Online Comment

Application H16-1131-21
Location 38 SPRING GARDENS SPALDING
Proposal Change of use of existing building from dance/fitness studio (class E) to 2 x 1-bed flats and 5 x 2-bed flats (class C3) including the formation of a pitched roof to existing single-storey projection

Name Greg Watkinson
Address Conservation Officer

Date Submitted 29-11-21
For/Against Comments

Rear Elevation (NW):

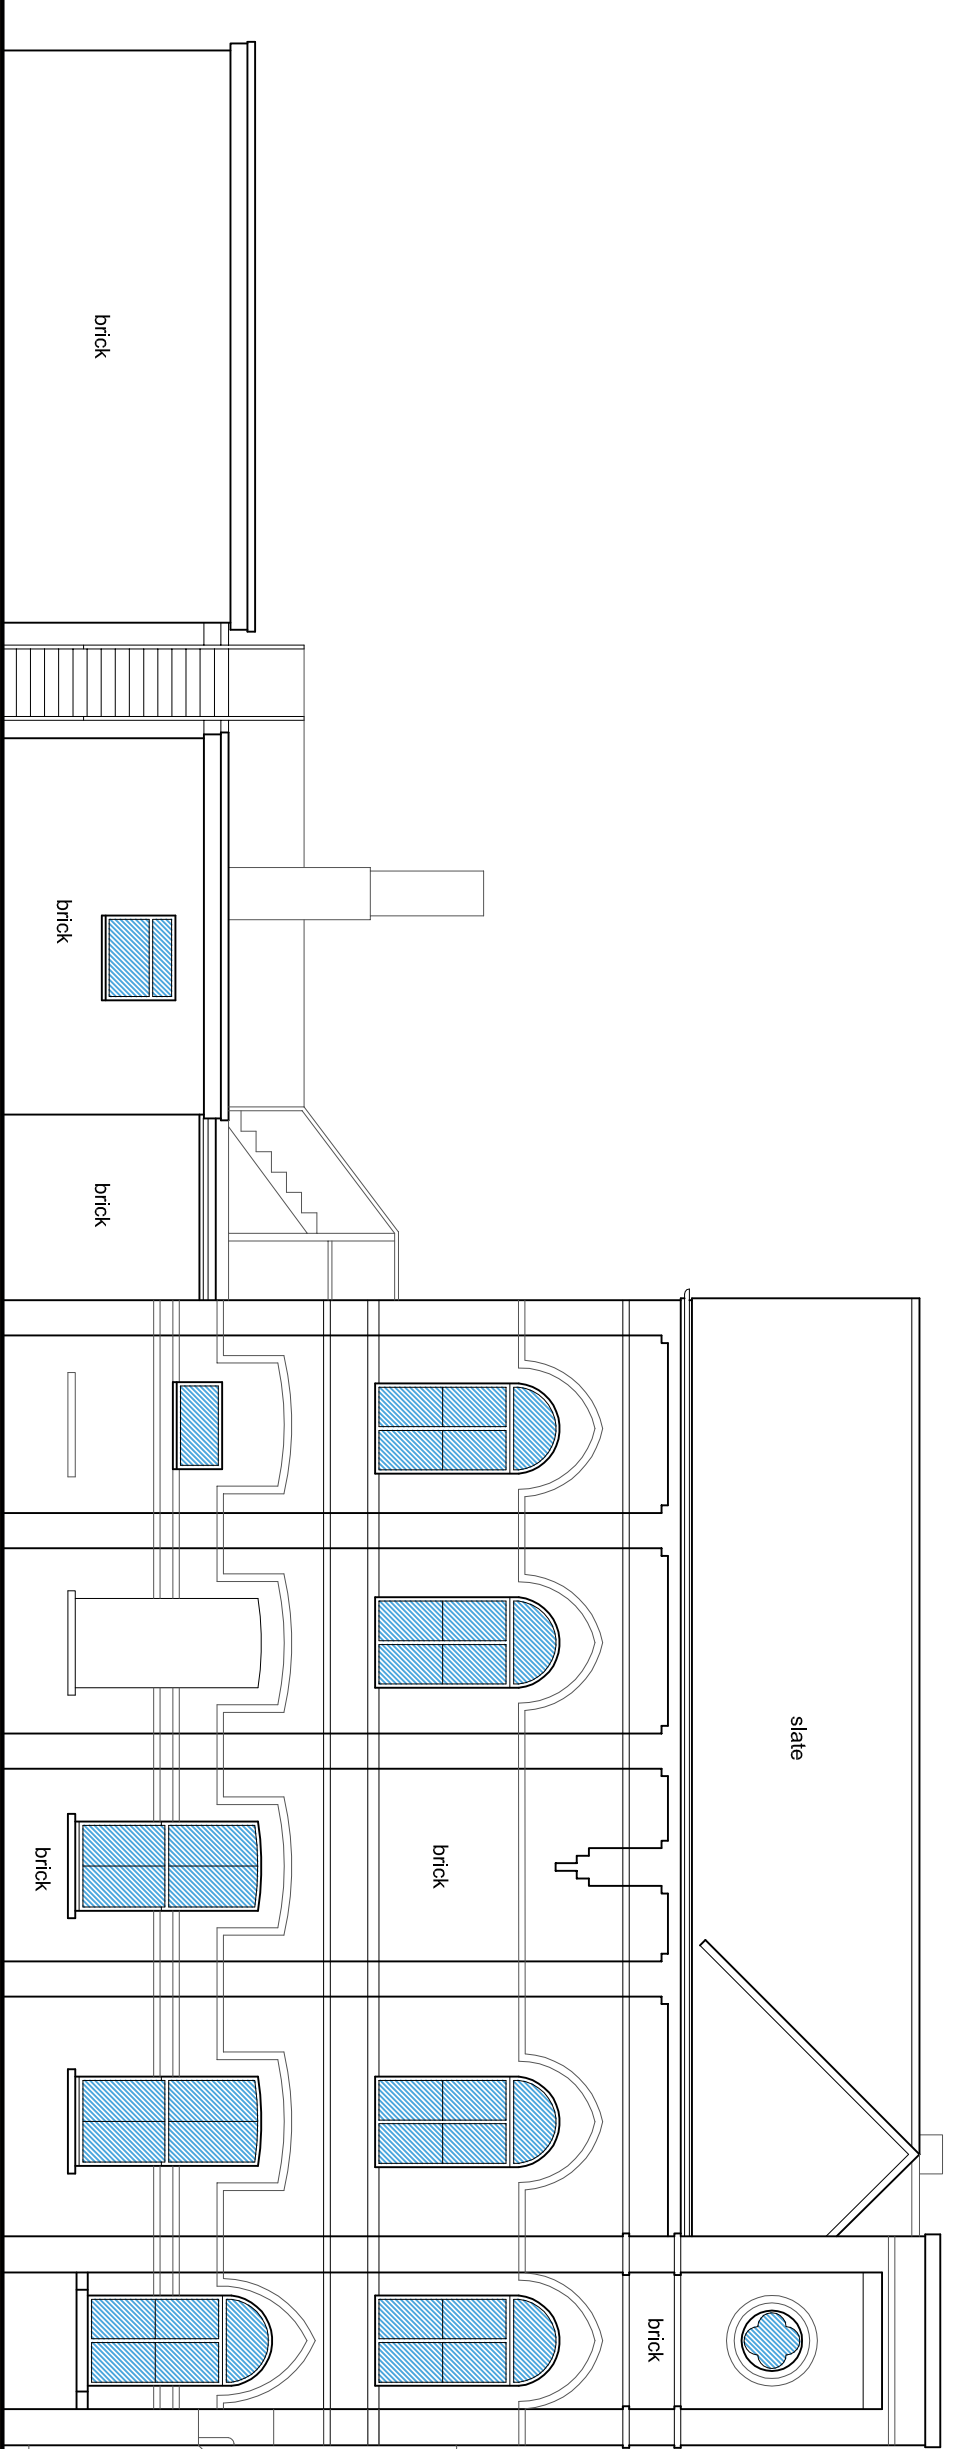
On conservation grounds, the principle behind converting this disused listed property to regular residential use is a sound one. Furthermore, I am satisfied with the proposed external alterations to the property, especially the addition of a slated pitched roof over the extant flat-roofed rear extension, which is currently a detracting factor to the aesthetic qualities of the site.

Section A-A

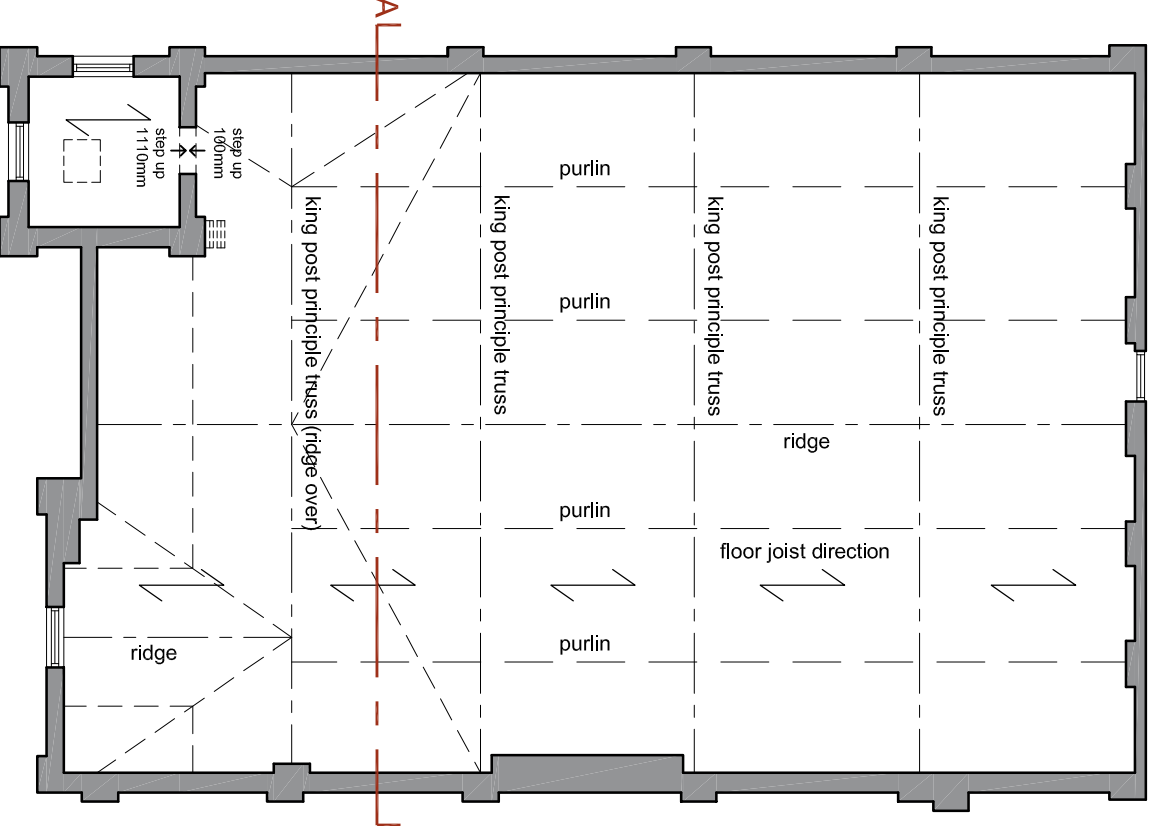
However, having visited the site, I am concerned that the subdivision plan of the 1st-floor dance hall/ballroom risks causing a total loss of significance to this portion of the interior, which is undoubtedly the single most significant source of interior character to this site. The grand, double-height ceiling, mouldings, ceiling roses, and wide-open space with ample access to sources of natural light would be lost with the proposed extensive subdivision and the addition of a full-size mezzanine floor. I would recommend that the applicant should be required to present an alternative floor plan proposal that substantially cuts down the subdivision on the 1st-floor level and that is more respectful of the internal character of the property.

As an absolute minimum, I would expect that mezzanine floors should be recessed from the windows in order to preserve the character and contribution of the full-height windows, and subdivision should be planned such that it does not affect the character features of the interior.
